Email: suds@kent.gov.uk
Tel: 03000 41 41 41
Our Ref: SBC/2023/093697

Application No: 22/505852/SUB

Location: Land Off Staple Street Hernhill Kent ME13 9HY

Proposal: Submission of Details Pursuant to condition 14 (Surface Water Drainage

Drawing Title: **PROPOSED DRAINAGE LAYOUT SHEET 2**

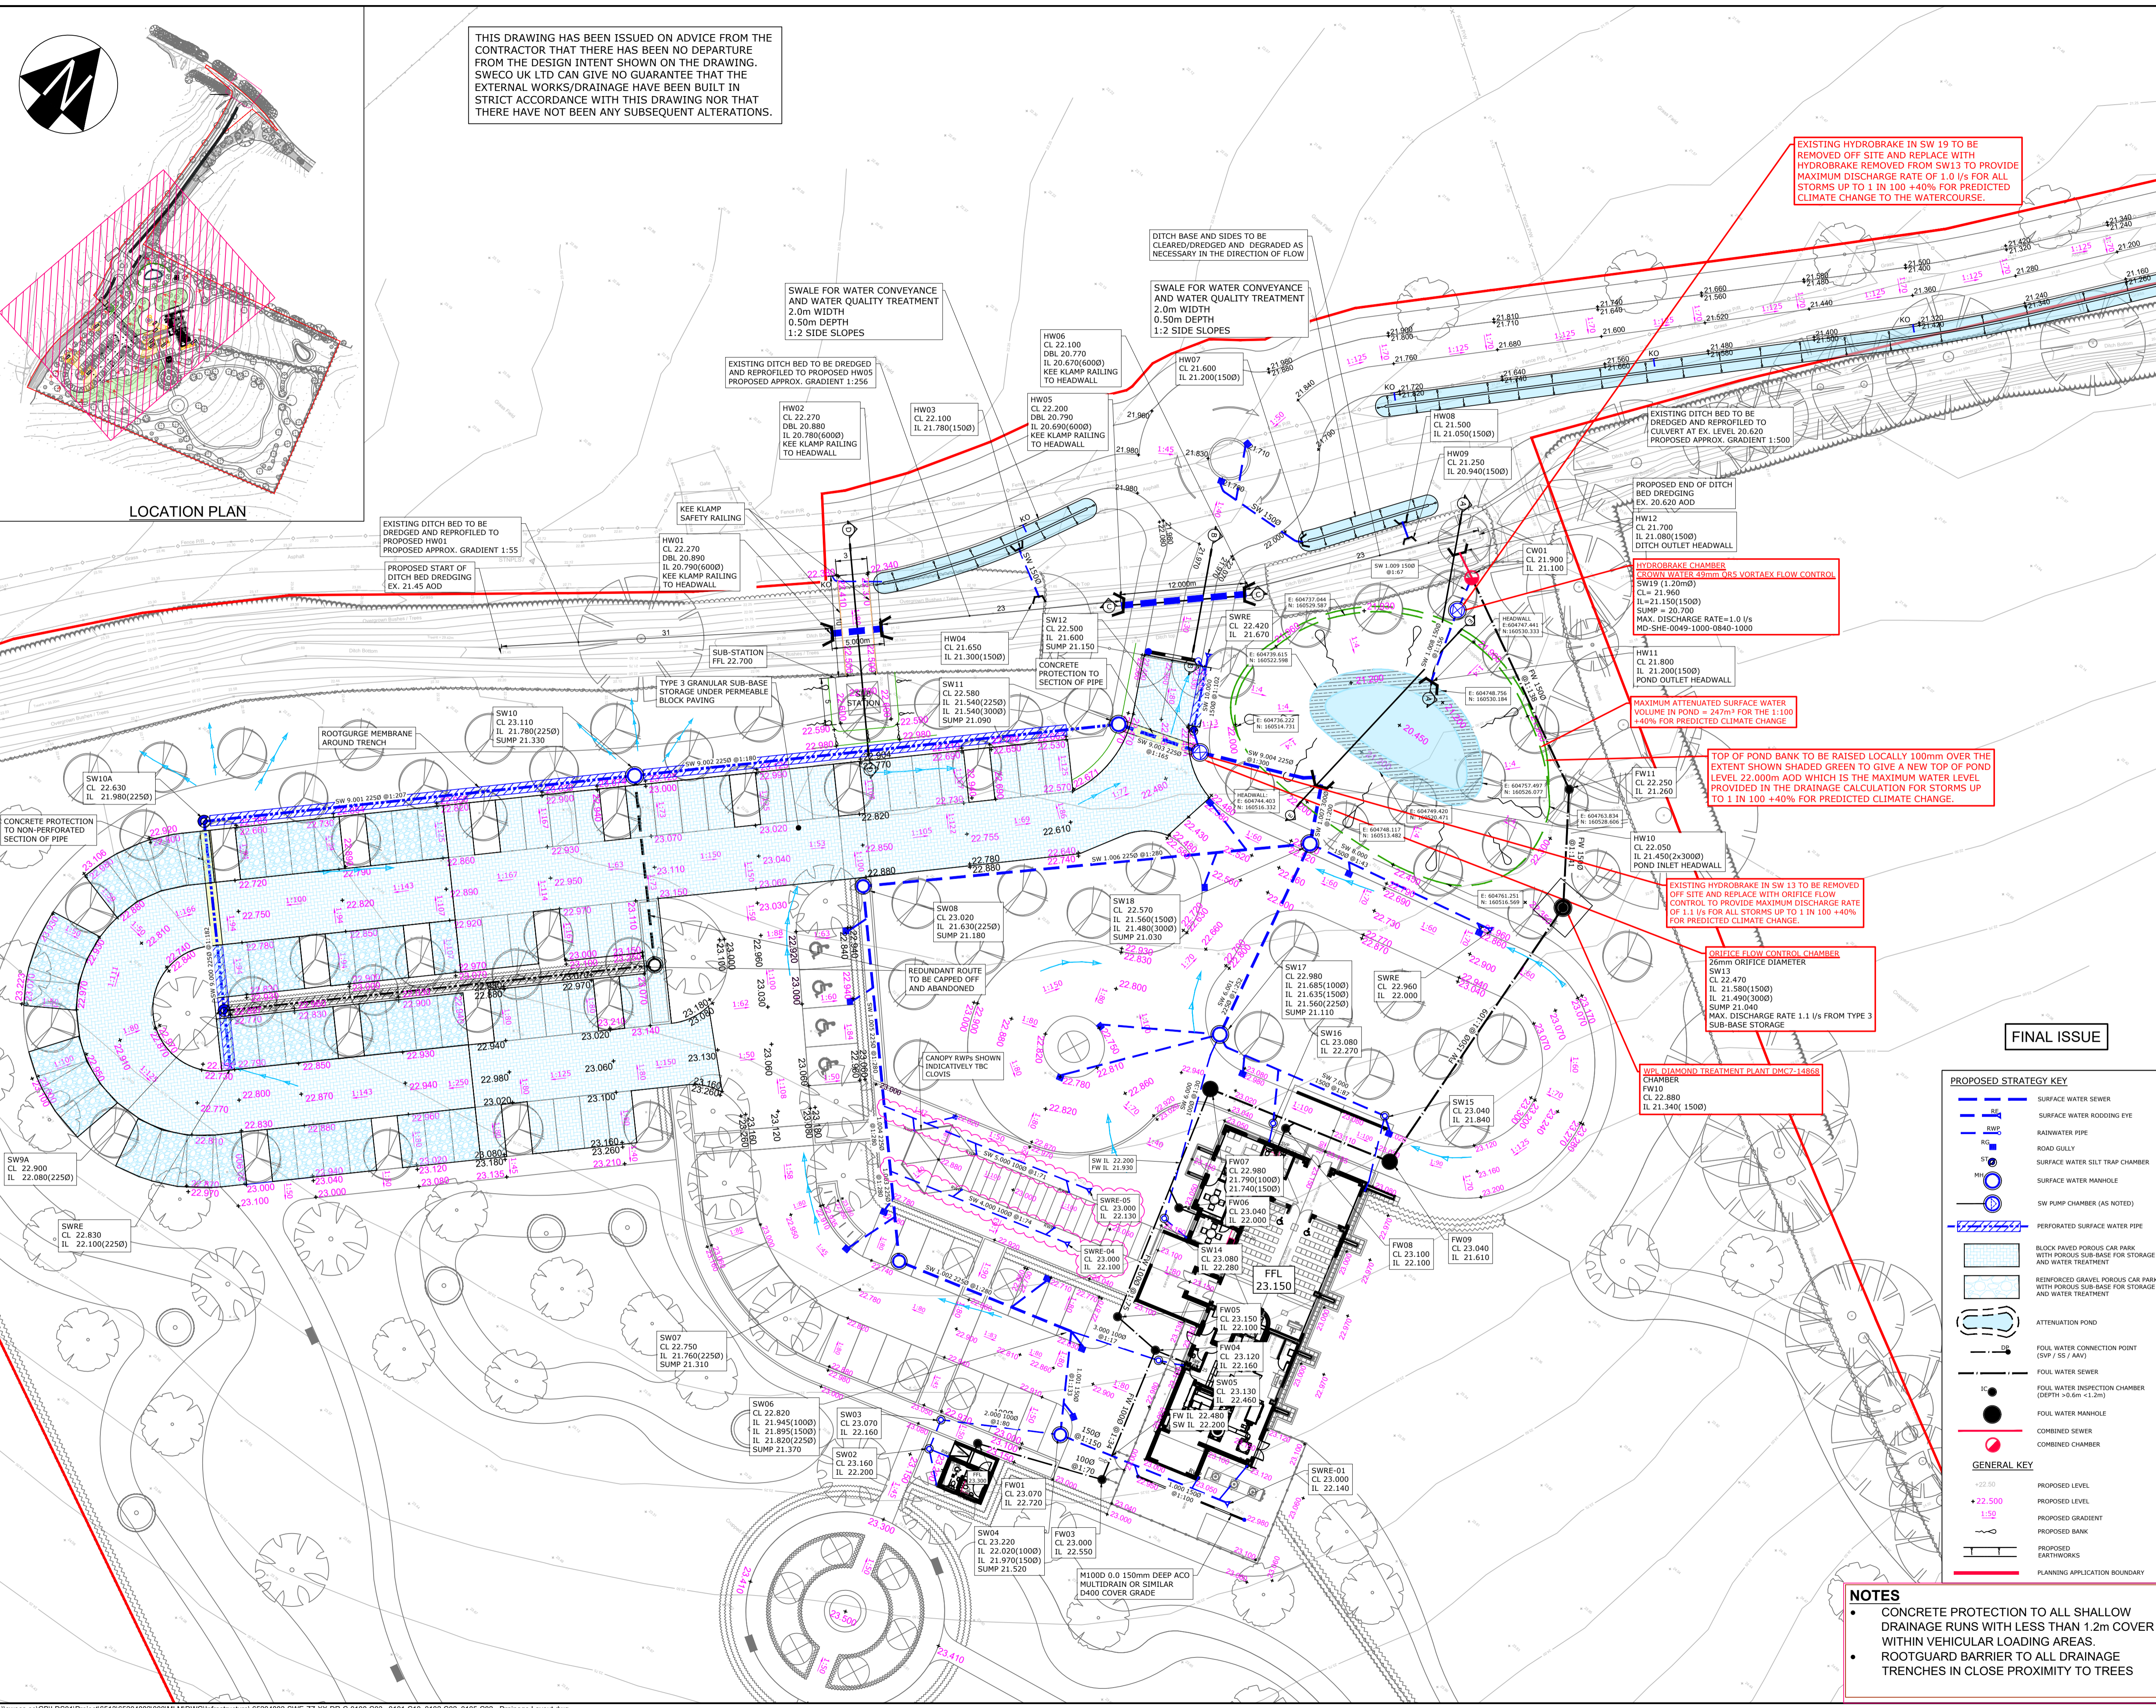
1. Whilst not raised within our previous consultation responses, we are note from Statement 2.4 of the Flood Risk Assessment provided as part of the full application (20/503666/FULL), that the outlet for the northern pond/watercourse passes under Staple Street and connects into the wider field ditch network. A subsequent review indicates that this connection to the wider network would likely be through the existence of a land drain and not an open watercourse feature as alluded to within the FRA. With the entrance of the site and pond being the low point, there have been resident comments highlighting this as a problematic area for flooding of the highway. In view of this, we have concerns as to the current condition/operation of this land drain.

In light of these concerns, we would request that a CCTV investigation is undertaken of the network downstream of the pond to ascertain its current condition. A failure/blockage of the land drain could be responsible for this periodic flooding to the junction and pond raised by resident comments. With the additional volume of surface water from the new development and on going discussions around the runoff rates from, there is therefore a rightful concern that this flooding could be increased if there is an existing problem with this drain.

3. From residents comments and supporting photographs, we are aware that an additional pipe connection has been made to the existing pond next to the access road (near to headwall serving swale outfall). The LLFA envisage that this pipe extends under the road junction to Staple Street however, we would request further clarification as to its purpose and route.
